Proposal: Discharge of Condition 2 (External Lighting Layout) of 22/01945/REM

- 2.1. This submission seeks consent to discharge condition 2 of 22/01945/REM, which relates to details of external lighting across the site.

- External Lighting Layout ref: 1760-ESC-00-ZZ-DR-E-2104 - P1 dated 23/5/22.

Drawing Title
External Lighting Layout

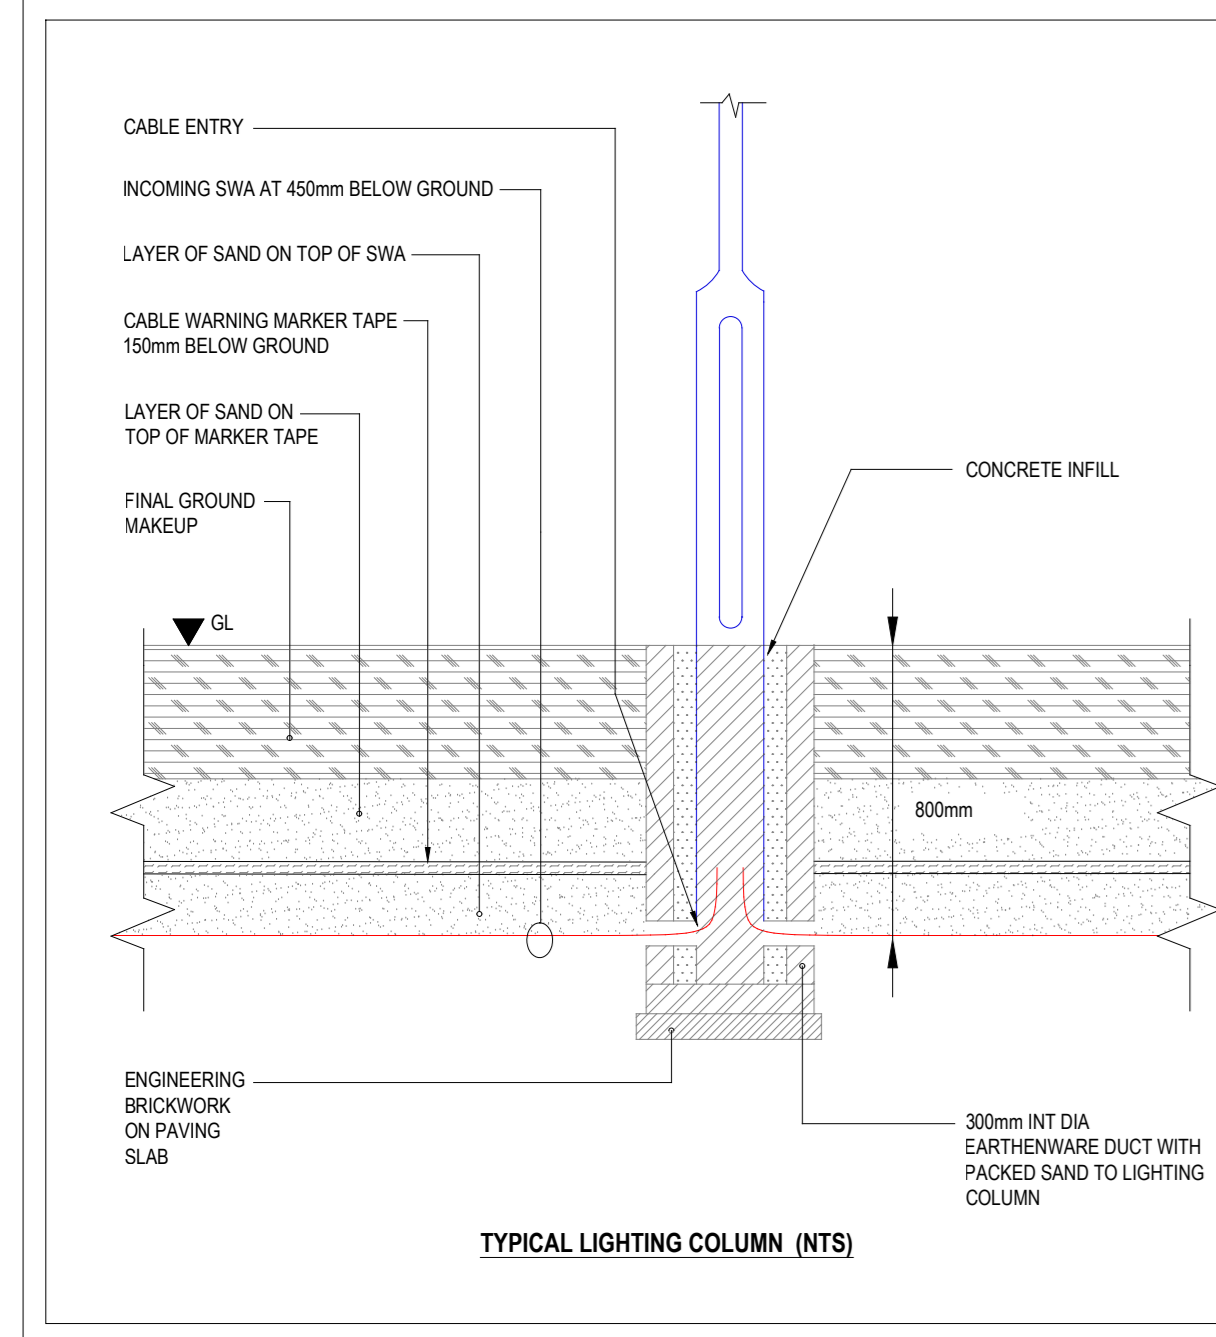
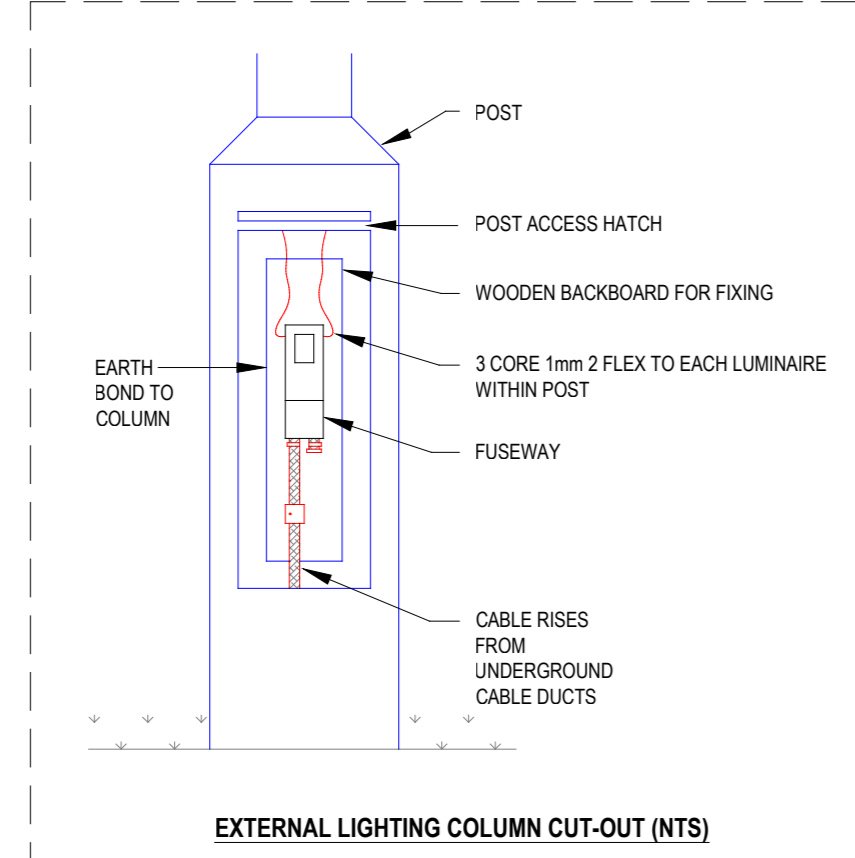
- 5.1. CDC Environmental Health – No objection. Happy for the condition to be discharged.
- 5.2. CDC Ecology (from 22/03692/DISC) - With regard to the above discharge of conditions specifically the lighting aspect - I have had some trouble viewing the plan however it appears that there will be significant light spill into most of the trees on site and particularly there will be spill into the trees bordering the green space to the East of at least 2 lux on average. Most bats, particularly the rarer species, are deterred by this level of light. 1 lux is equivalent to twilight and lighter than this will affect the way nocturnal wildlife can use the site. If possible I would look to try to reduce this spill onto vegetation, in particular pulling it back from the vegetation bordering the biodiversity mitigation area. I could not see any information on the proposed timing of lighting (time of year in use, whether some will be responsive lighting, will it be on all night etc..) and this would make a significant difference to its potential impact. Ideally I would request this information is submitted.

- 6.2. Whilst the comments from the Ecology Officer are noted, the lighting details submitted to discharge this submission are listed as an approved drawing under the REM for phase 2 (22/01632/REM). The relationship between Phase 3 (to which this application to discharge conditions relates) and the open area to east is similar to Phase 2, but the shared boundary length is much less (circa 110m) – limiting the potential impacts of lighting in comparison to Phase 2.

- 6.3. Given that the lighting scheme has already been judged to be acceptable for Phase 2 (and therein there is no limitation on hours of operation), it is not considered that the current submission could be reasonably refused on the basis of light spill/operational hours. As such, the details are considered sufficient to discharge the requirements of the condition.
